From: stephen jupp 
Sent: 07 November 2018 11:36
To: Simon Davis
Subject: Re: BN/50/18/PL The Fallows

I am just looking at your application BN/50/18/PL. I think the current plans, descriptions are not clear and I would like to change the description to say: "Erection of 1 No. replacement dwelling and conversion of existing outbuilding (approved dwelling) into double garage".

| CLIENT | PROJECT                | TITLE                                                               | STATUS   | DRAWN BY   | REVIEWED BY    |
|--------|------------------------|---------------------------------------------------------------------|----------|------------|----------------|
|        |                        |                                                                     | 05.07.18 | 1:100 @ A1 | 16             |

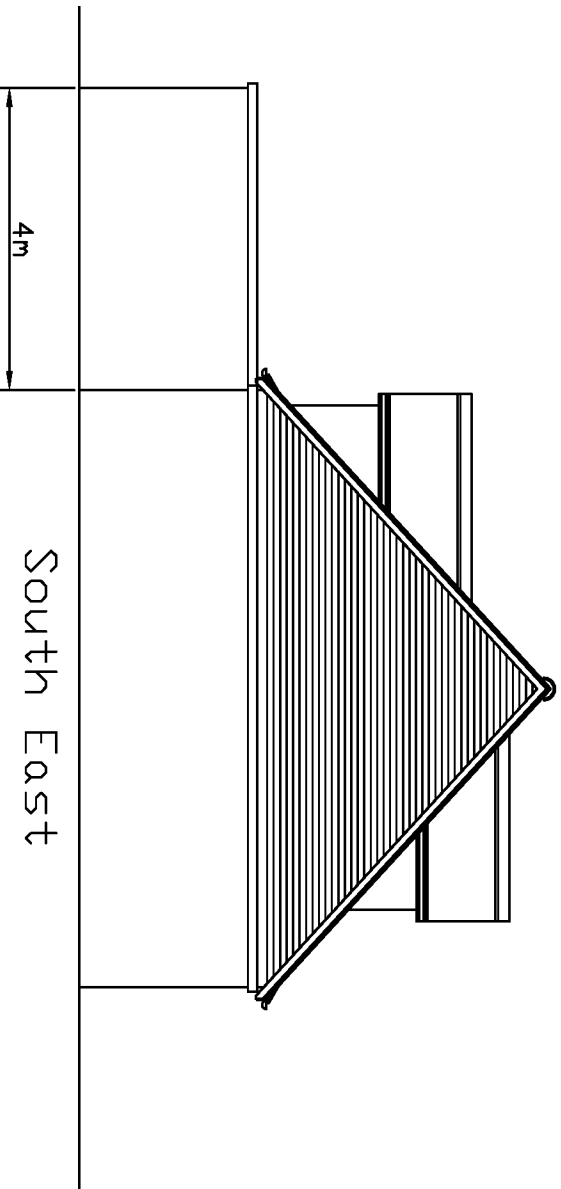
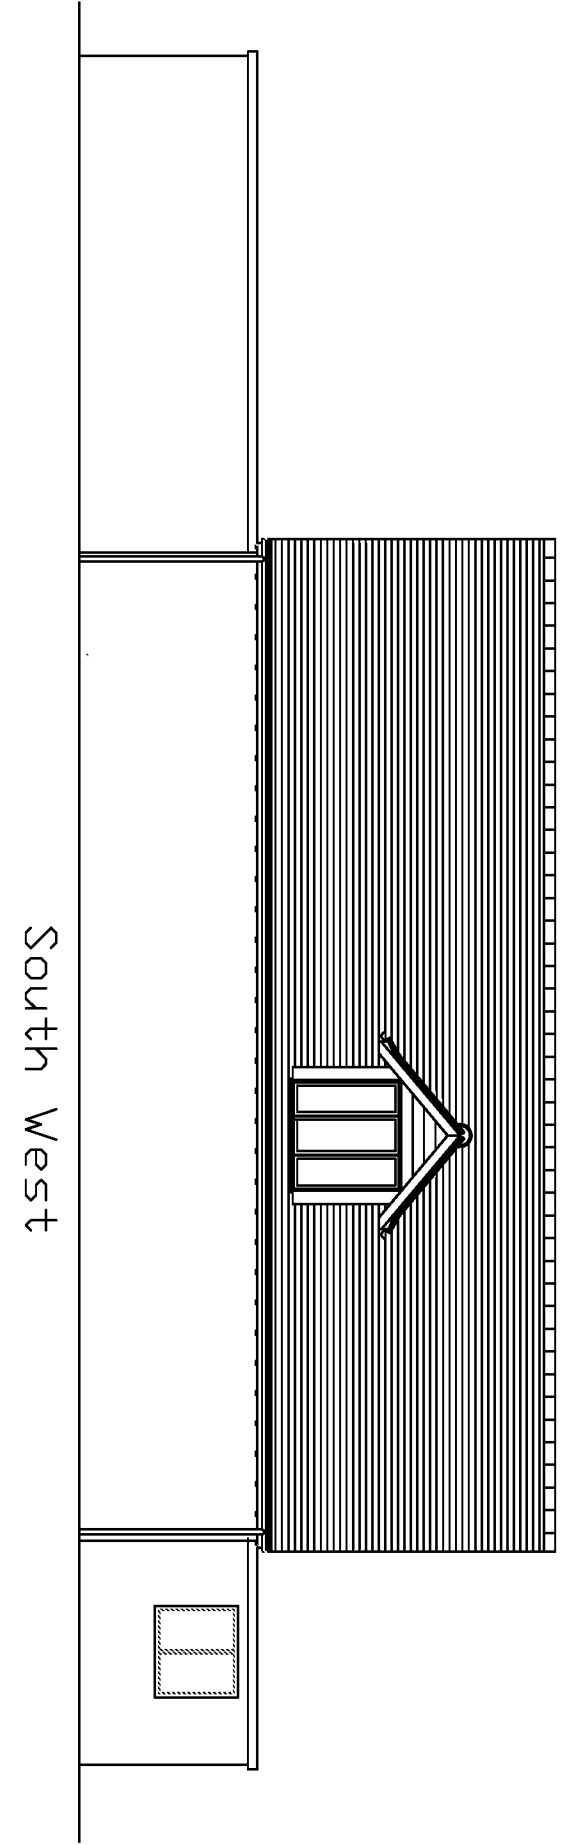
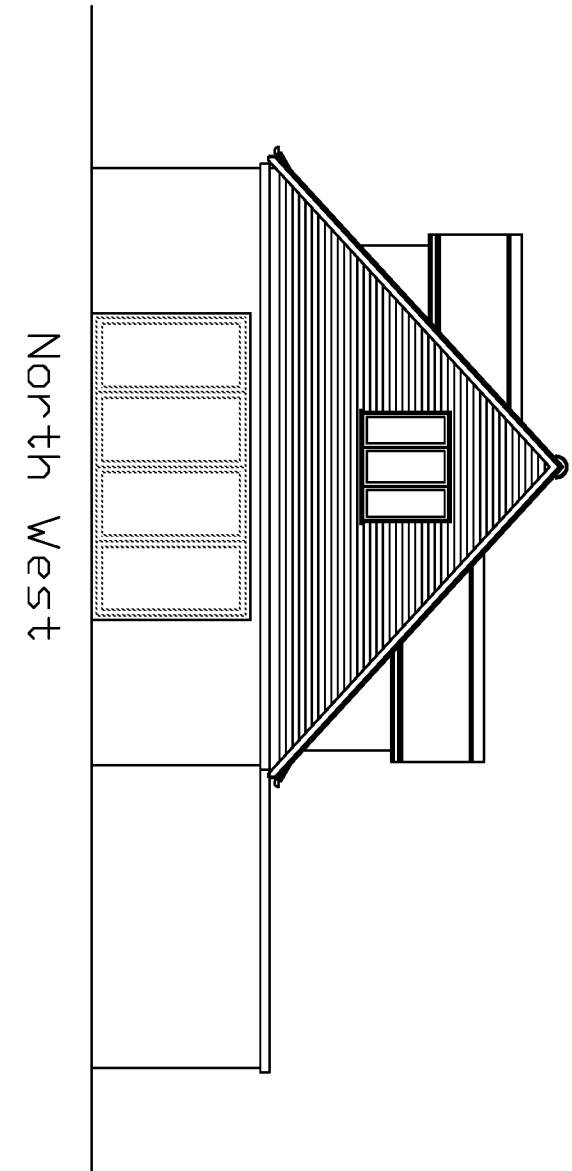
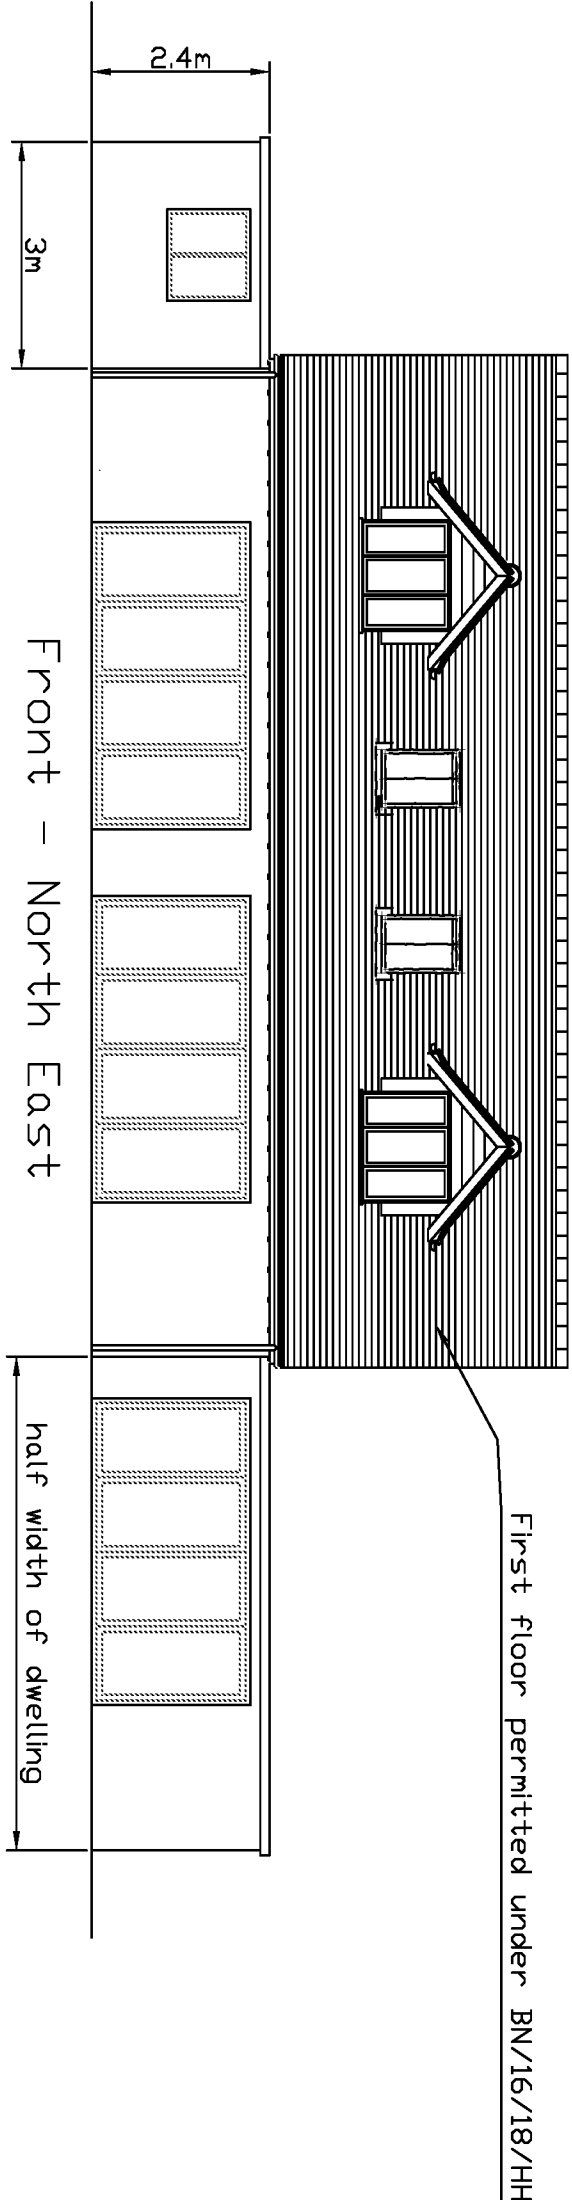
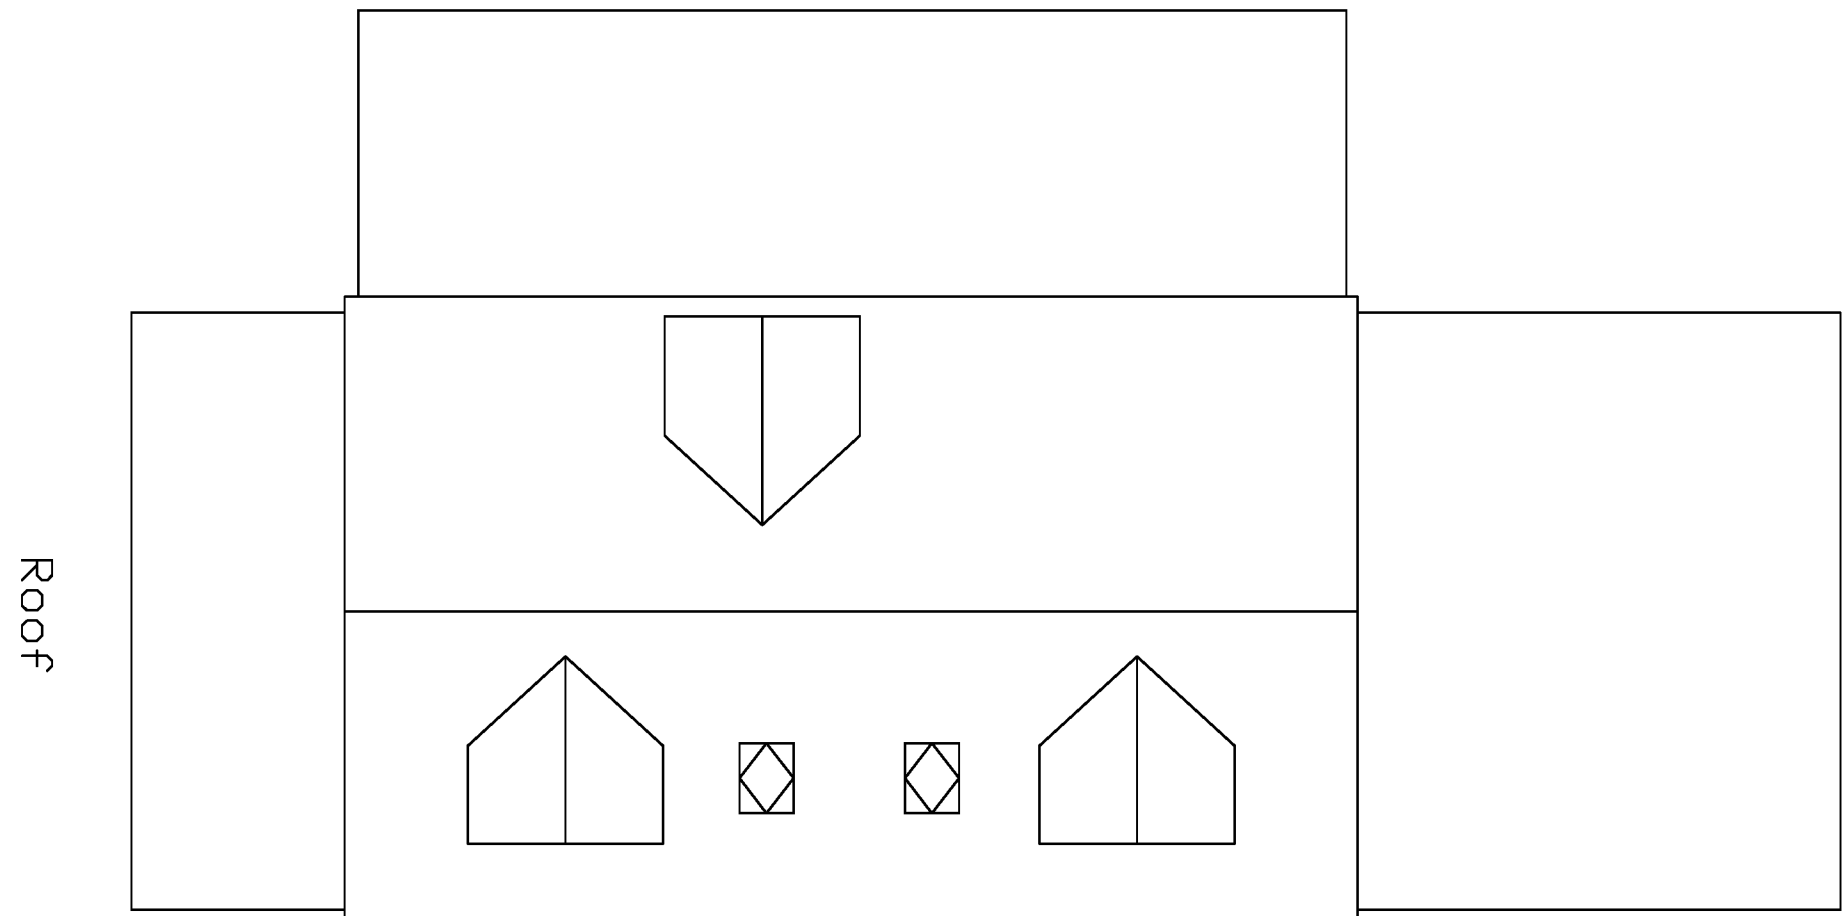
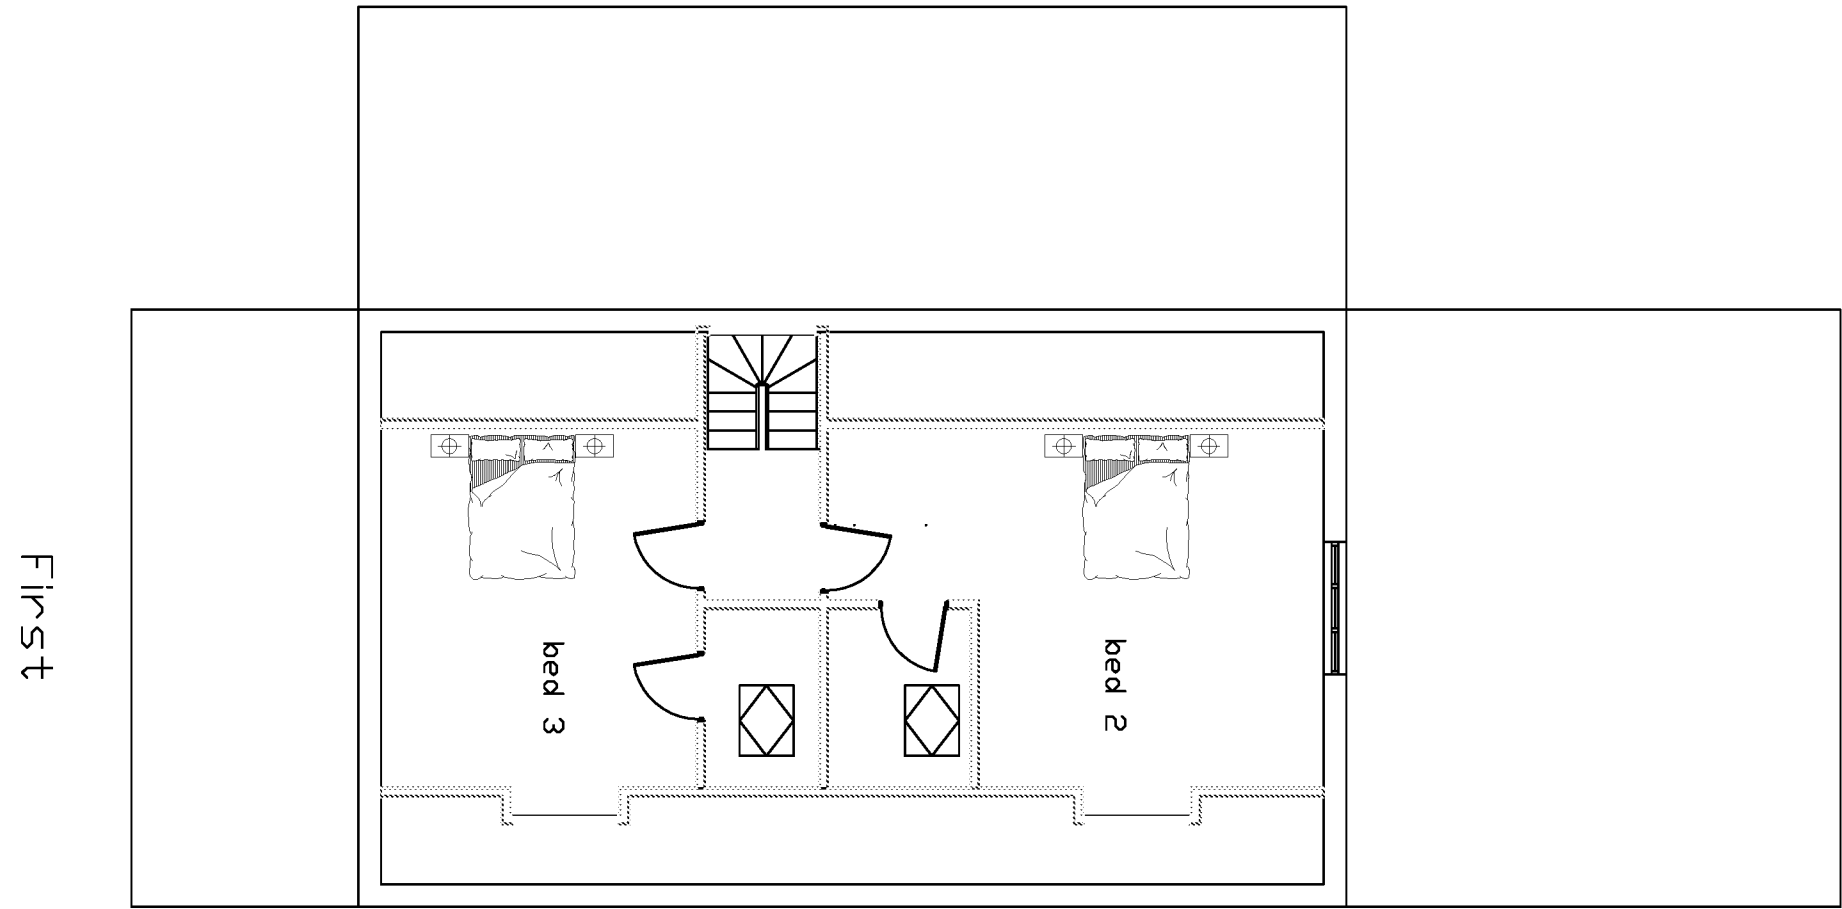
Can you also withdraw Dwg 16 "Permitted Floors, Roof & Elevations plans" as this is not relevant to what you now want to do. Please can you then amend the Dwg 3 "Proposed Site Plan" to remove the references to the permitted extensions to the outbuilding and just show the outbuilding as the garage that you are proposing.

amended description hereby agreed
amended site plan attached
drawing 16 hereby withdrawn

Drawing 3 - Proposed Site Plan
Scale 1:500 @ A1

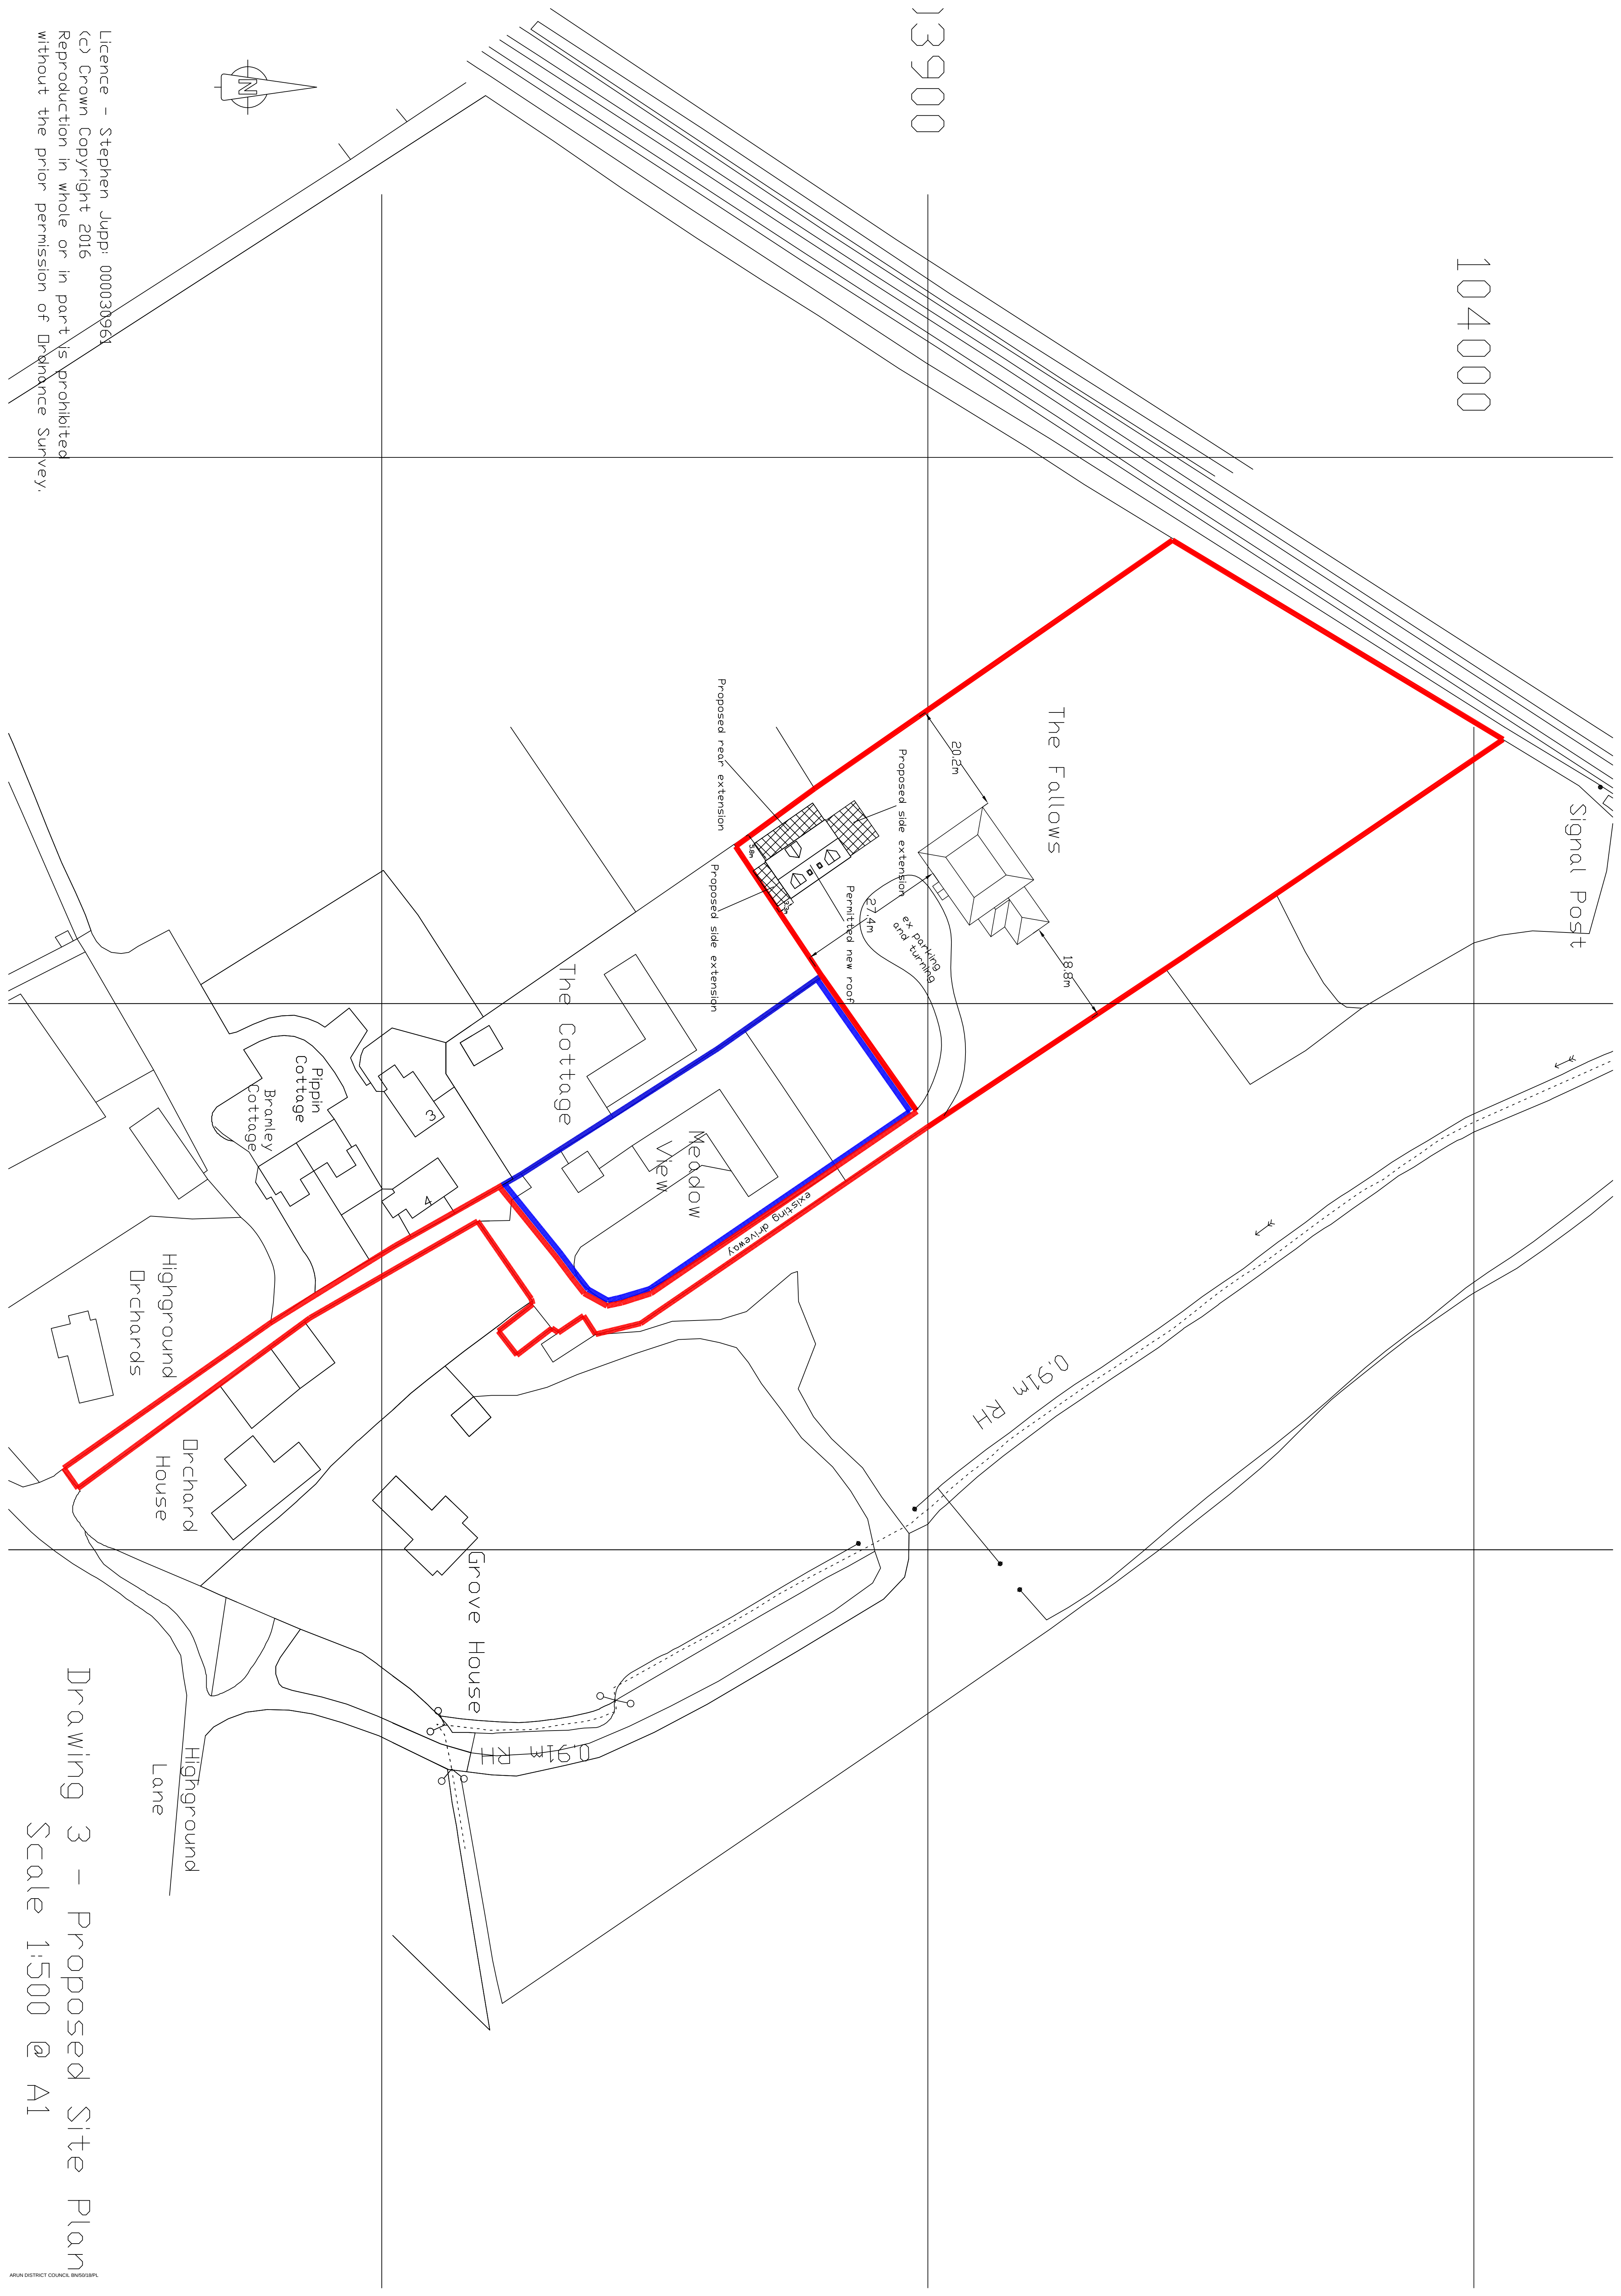
My concern is that someone will look at this and not read the planning statement and think that you are proposing one large house and also domestic extensions to the outbuilding.
